**RE: Legacy Church – Green Mountain Falls CDOT and El Paso County Comments**

Thank you for the comments on December 4<sup>th</sup> and 28<sup>th</sup>, 2019 for the above-mentioned project. In an effort to address your comments concisely and simplify your review process, we have summarized your comments and our responses below.

REV: 11/22/19
REV: 10/18/19
PROPOSED DRAINAGE PLAN
SHEET 2 OF 3

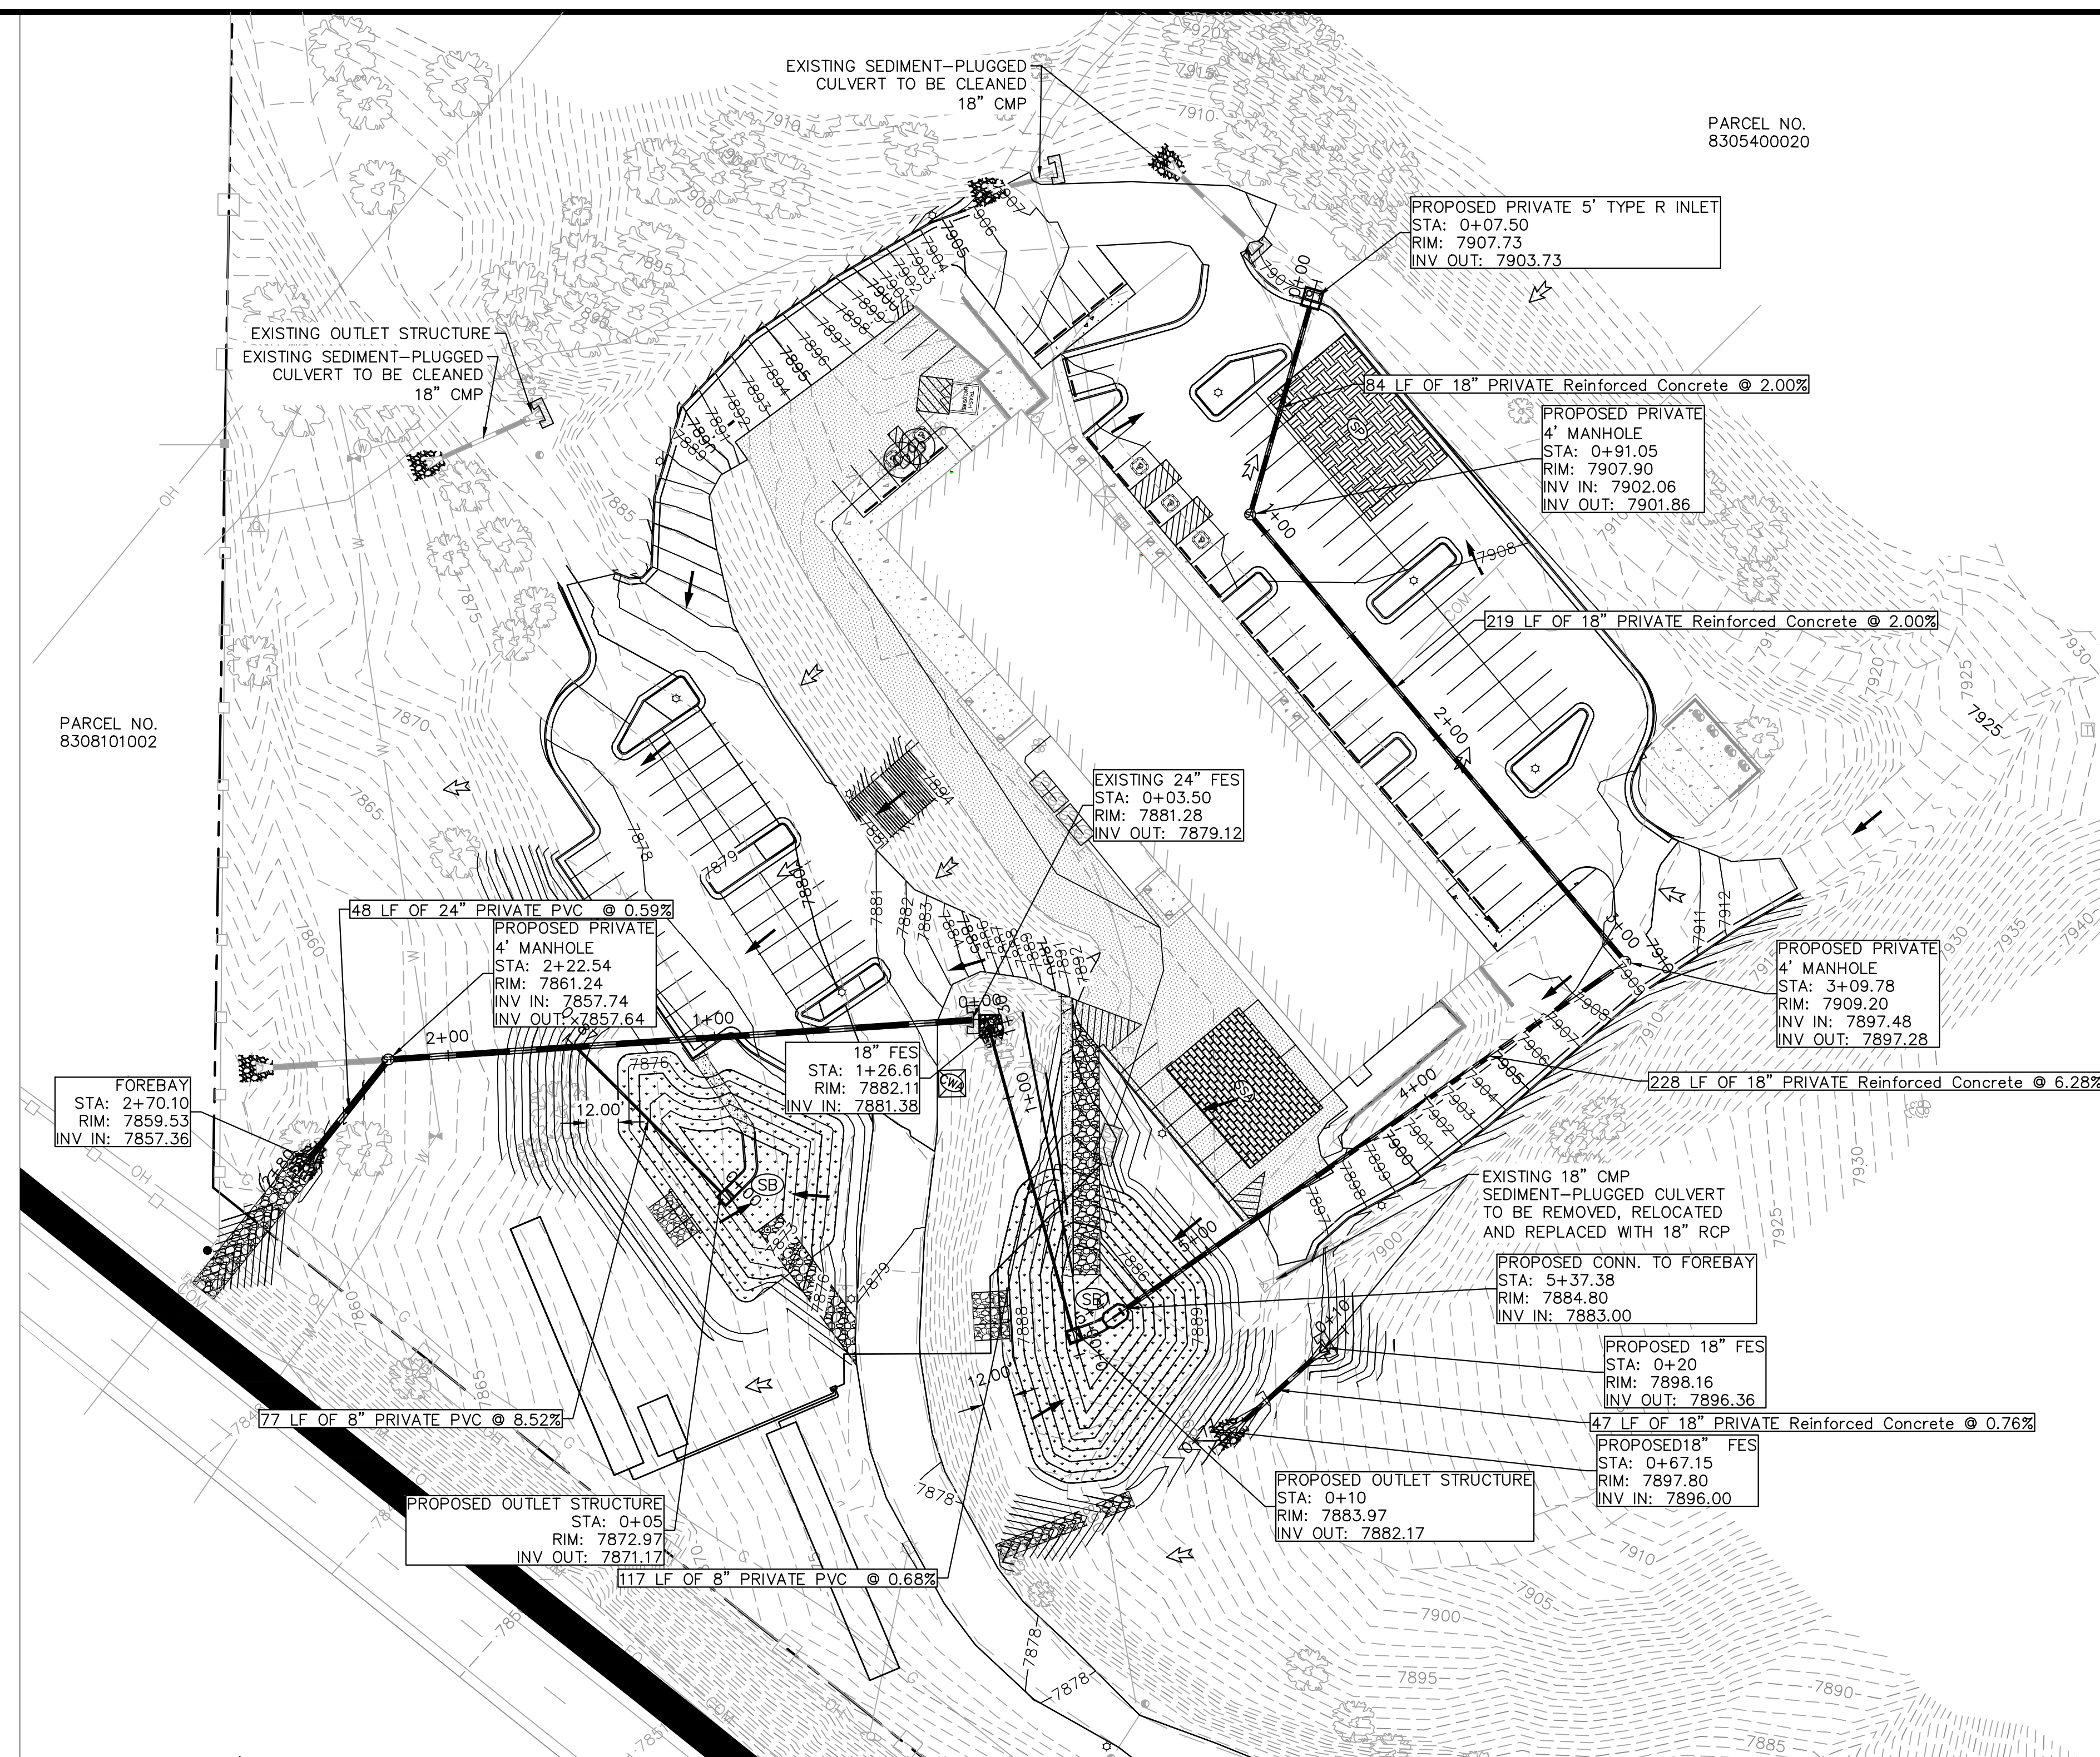
4. The drainage plan shows proposed grading in this area to divert the offsite flow away from the pond. Also, the drainage plan indicates that the existing culvert will be relocated and there appears to be protection provided downstream. Please include a description of this in the narrative.

12. A culvert and ditch were added southeast of the east detention basin. This ditch outfall onto church access road. This concentrated flow outfall condition will cause erosion along the edge of the proposed drive and likely undermine the pavement as well as cause icing issues in winter. Please provide a way for this water to drain either in a ditch along the access road or another culvert under the access road to prevent erosion.

*Response: The descriptions of the flows and protection have been added to this section.*

*Response: The proposed ditch southeast of the east detention pond outfalls into an existing ditch. Additional linework has been added to clarify this ditch location. Additionally, a detail has been provided on the Proposed Drainage Plan that outlines additional construction measures to ensure the ditch provides adequate capacity to the outfall at Design Point O-2.*
